PL- Consultation- Private Sector Housing & Public Health (Environmental Health) response

Planning Consultation on BR/52/26/PL

The Private Sector Housing and Public health team make the following comments, observations and requirements in regard to the proposed Change of use from dwelling house (use class C3) to 7-bed, 8-person house in multiple occupation (Sui Generis) to include a rear extension and loft conversion.

Application No:	BR/52/26/PL
Registered:	9th April 2026
Site Address:	28 Argyle Road Bognor Regis PO21 1DZ
Grid Reference:	493224 99065
Description of Works:	Change of use from dwelling house (use class C3) to 7-bed, 8-person house in multiple occupation (Sui Generis) to include a rear extension and loft conversion. This application is in CIL Zone 4 (Zero Rated) as other development.

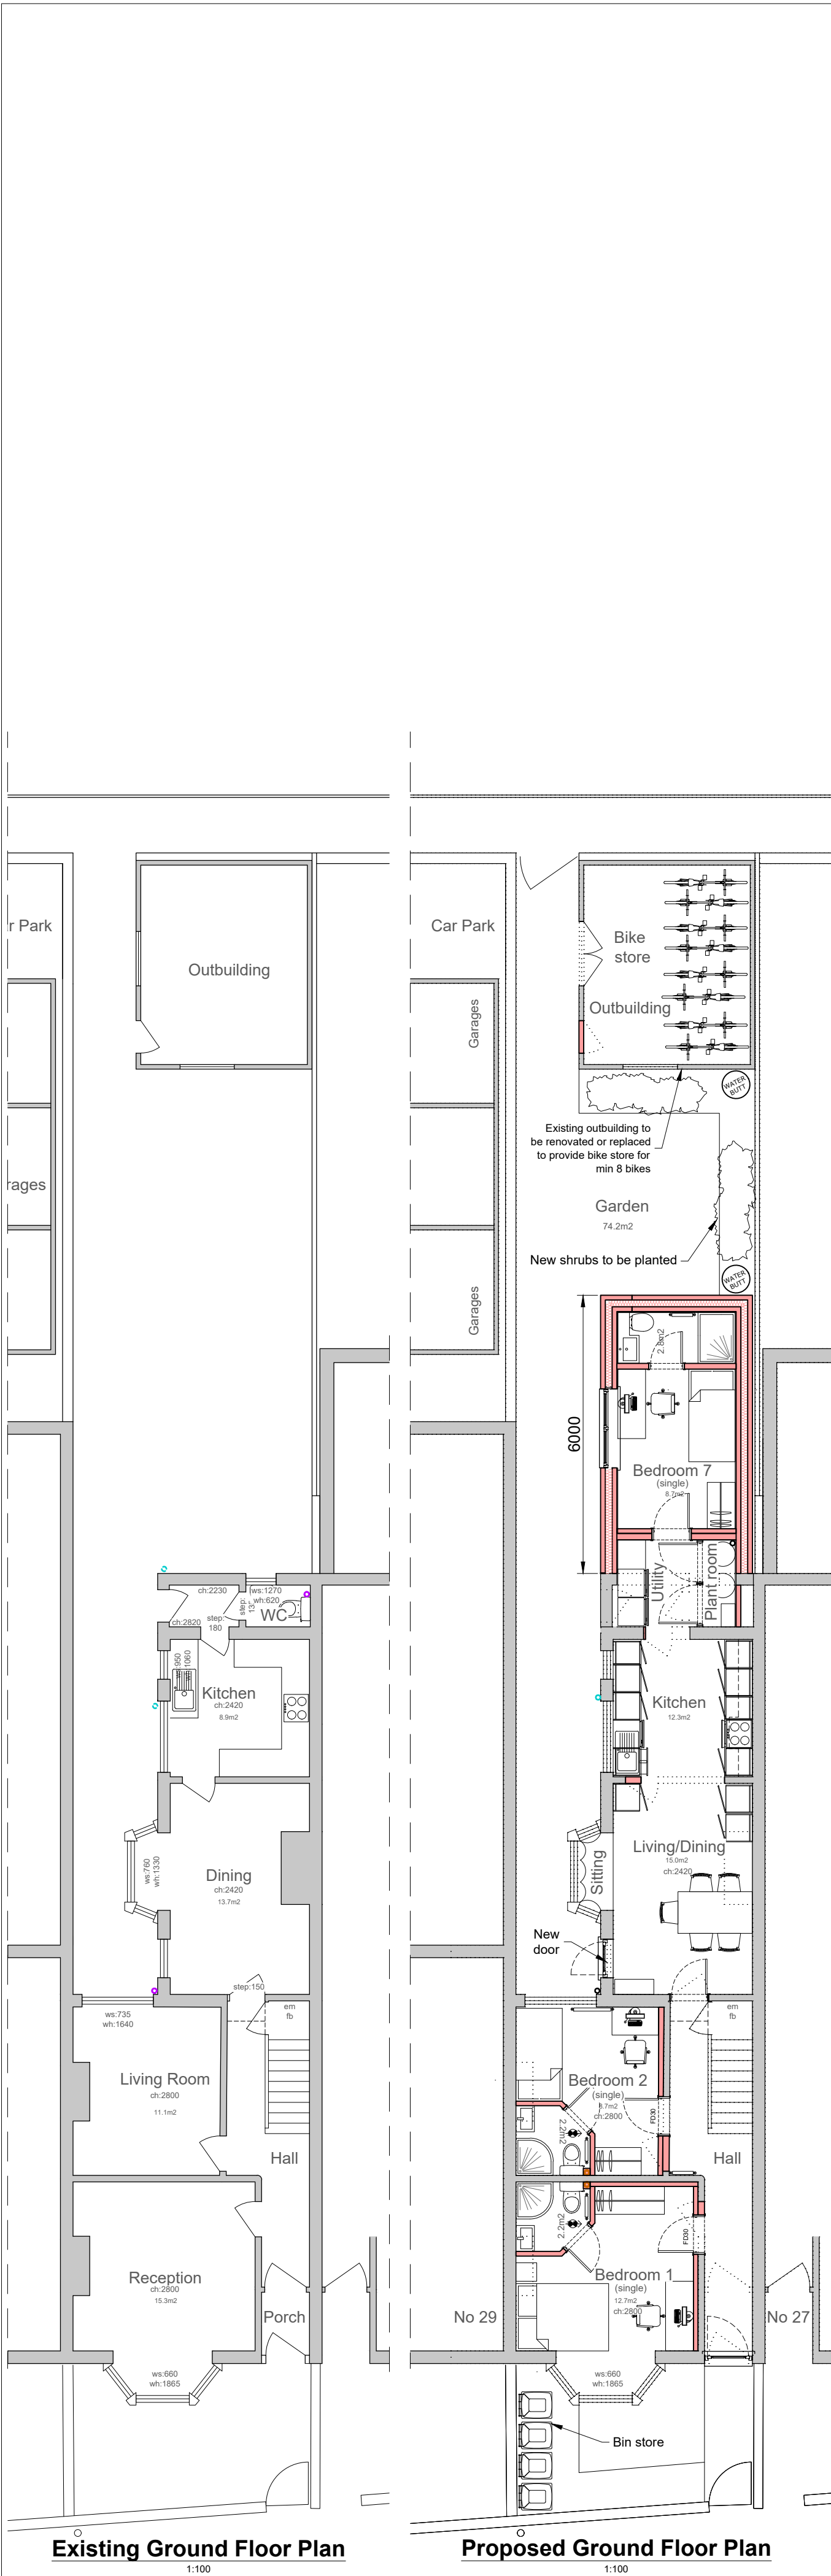
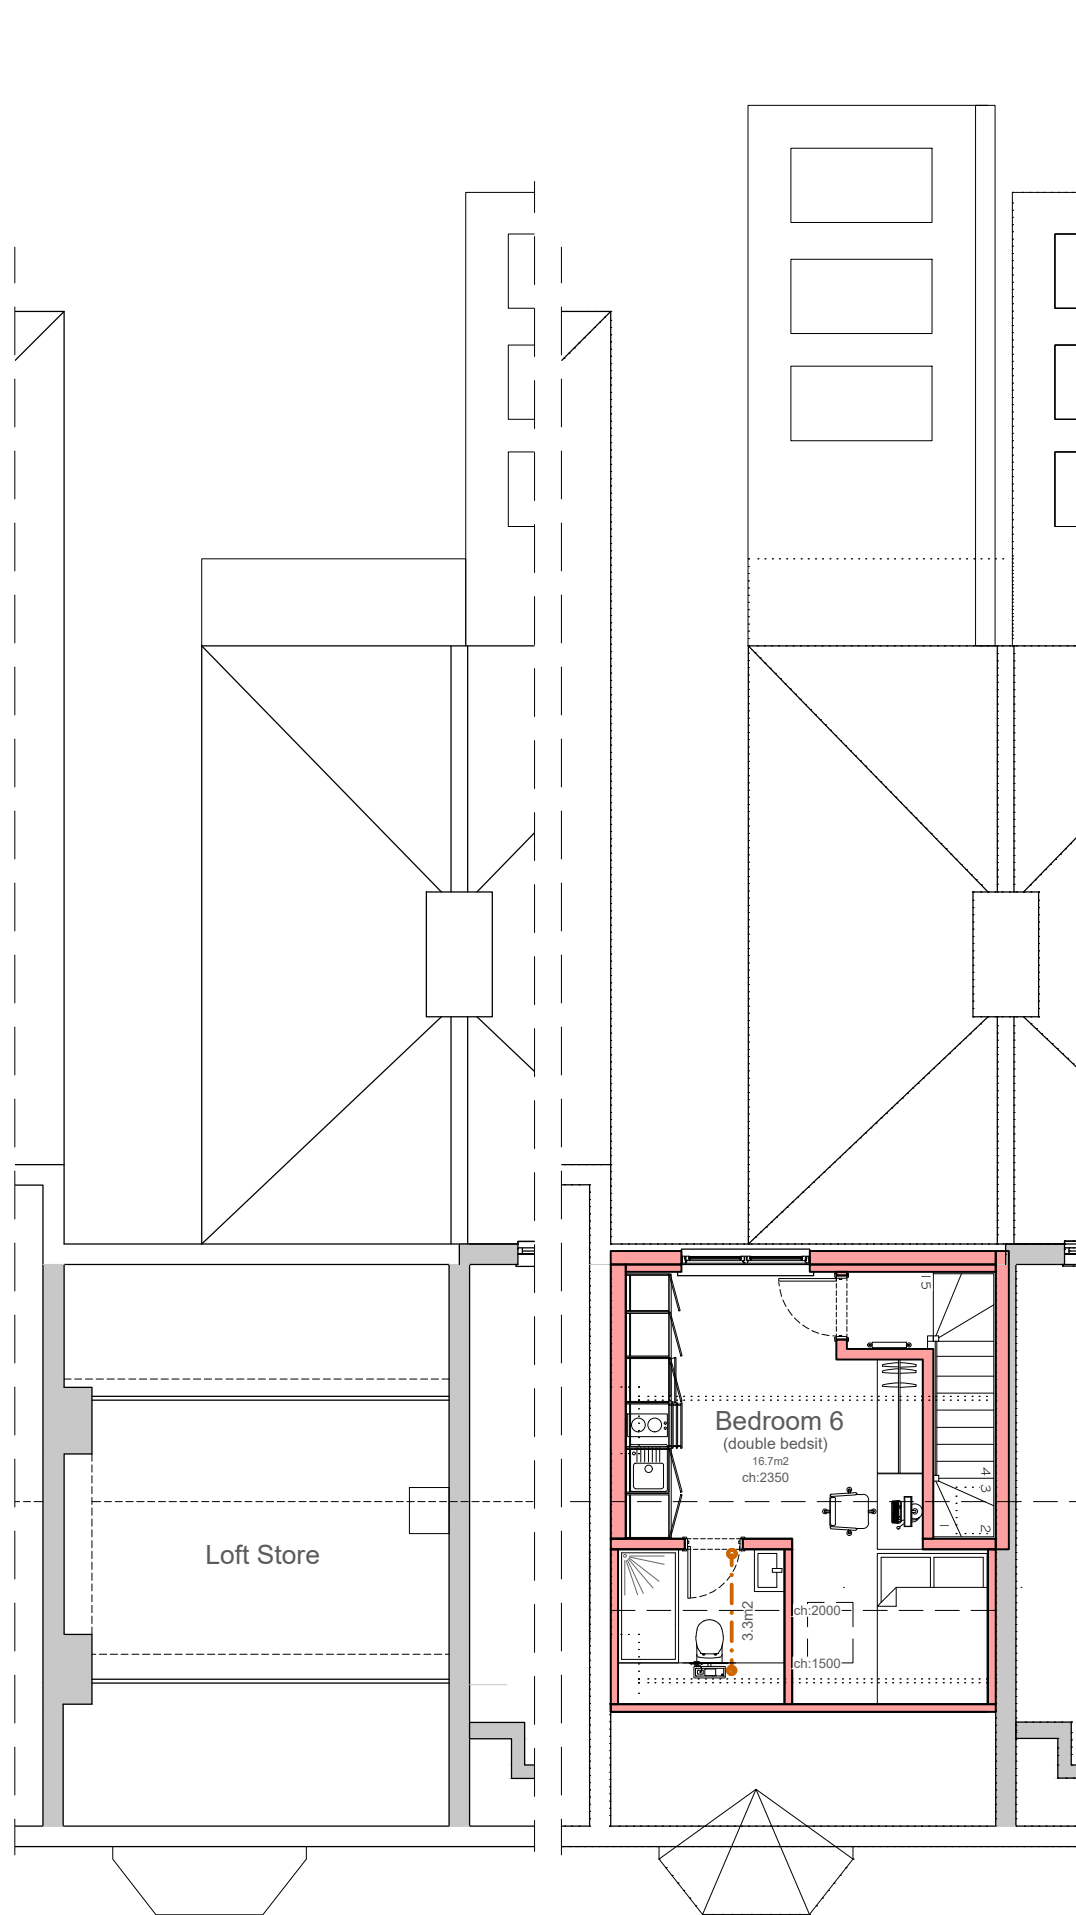
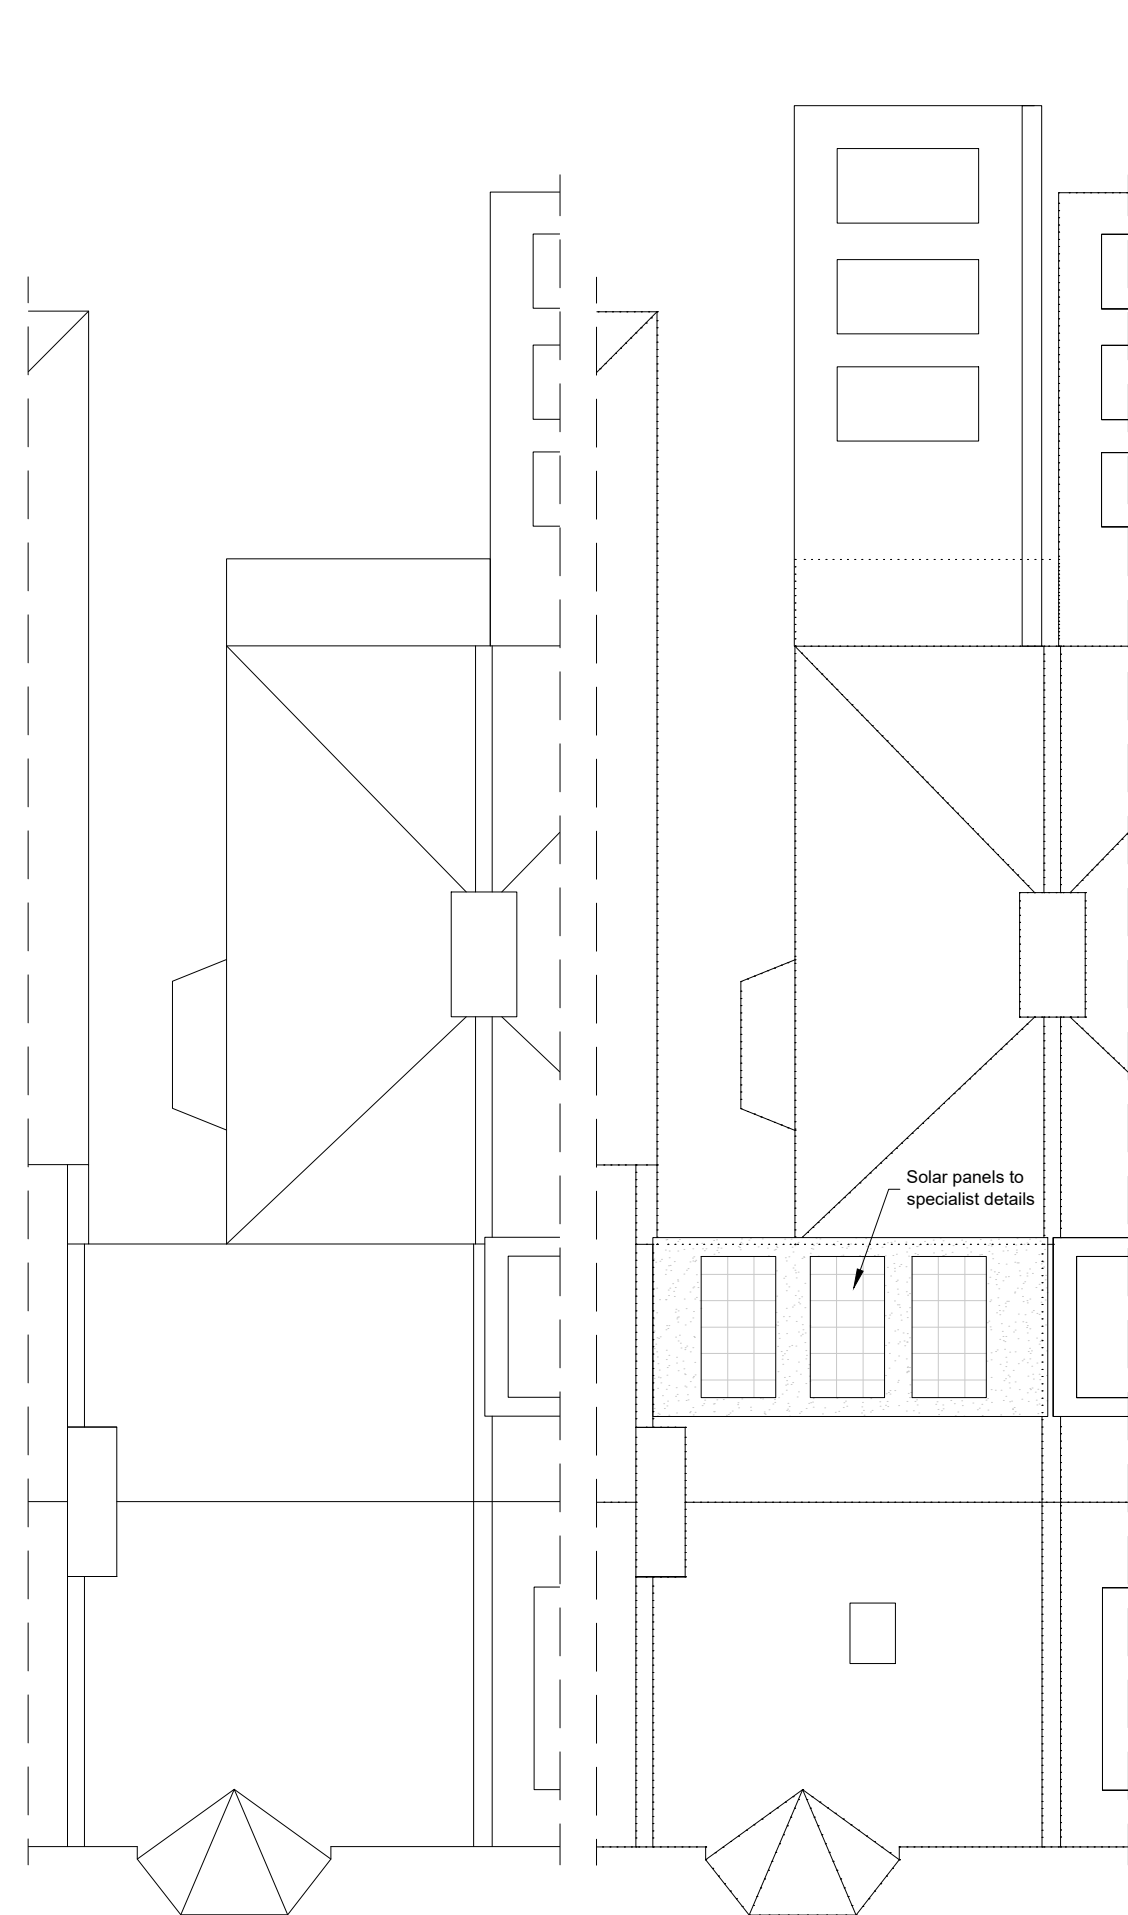
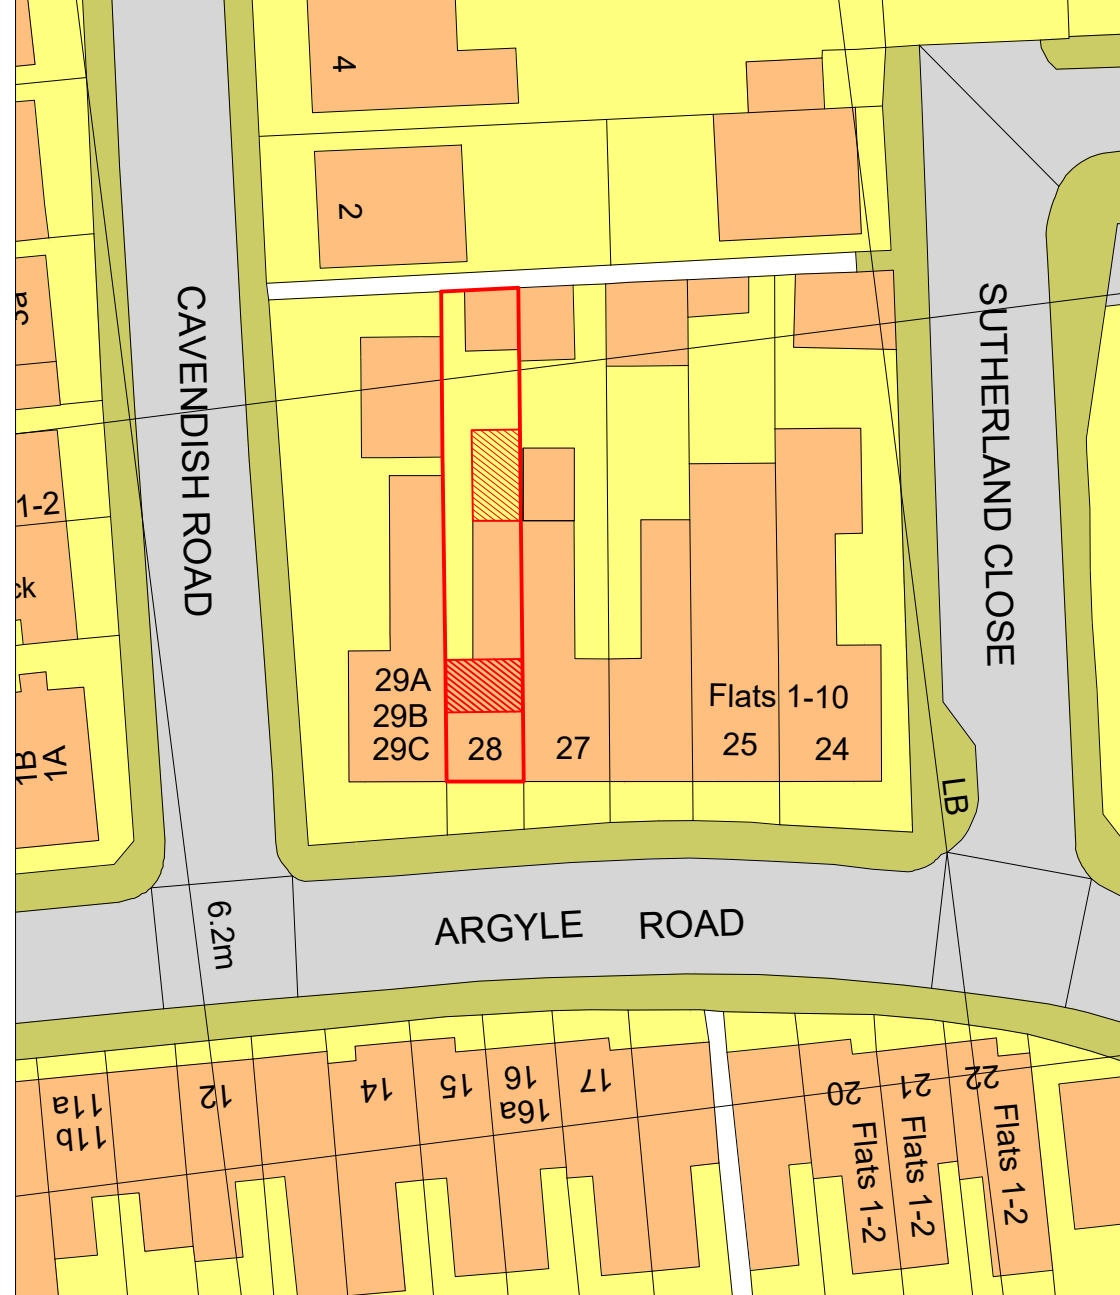
- As Bedroom 7 is an inner room and has to pass through the utility room and kitchen-diner as its normal egress route, an emergency escape window must be provided in this room. See below for requirements for escape windows.

- A 30-minute fire door must be provided between the kitchen and the ground floor rear bedroom (Bedroom 7). The door must be fitted with an intumescent strip, cold smoke seal, an overhead self-closing device capable of closing the door from any angle, be hung using three fire-rated hinges and have a thumb-turn inner latch.

- A 30-minute fire door must be provided to Bedroom 3 and Bedroom 6. Doors must be fitted with an intumescent strip, cold smoke seal, an overhead self-closing device capable of closing the door from any angle, be hung using three fire-rated hinges and have a thumb-turn inner latch.

The bedroom is identified as being a double bedsit; however, it also has a part-sloped ceiling and therefore the stated room size of 16.7m² may not be the actual size of the room when any space where the floor to ceiling height is under 1.5m has been subtracted from the overall room size, and therefore below the minimum size required for a 2-person bedsit under the Council's HMO Standards. In addition, the suggested placement of the double bed means that one person has to either climb over the other occupant to get to the side nearest the wall, or the first occupant always has to use one side (the one nearest the wall). It may be more suitable if Bedroom 6 was a single occupancy room and Bedroom 3, which is a larger room anyway (but also has its own cooking facilities and en-suite shower room) and identified as a single bedsit, was used as a double bedsit as it would allow i). more room for two people, and ii). Allow for the occupants to get in both sides of the bed.
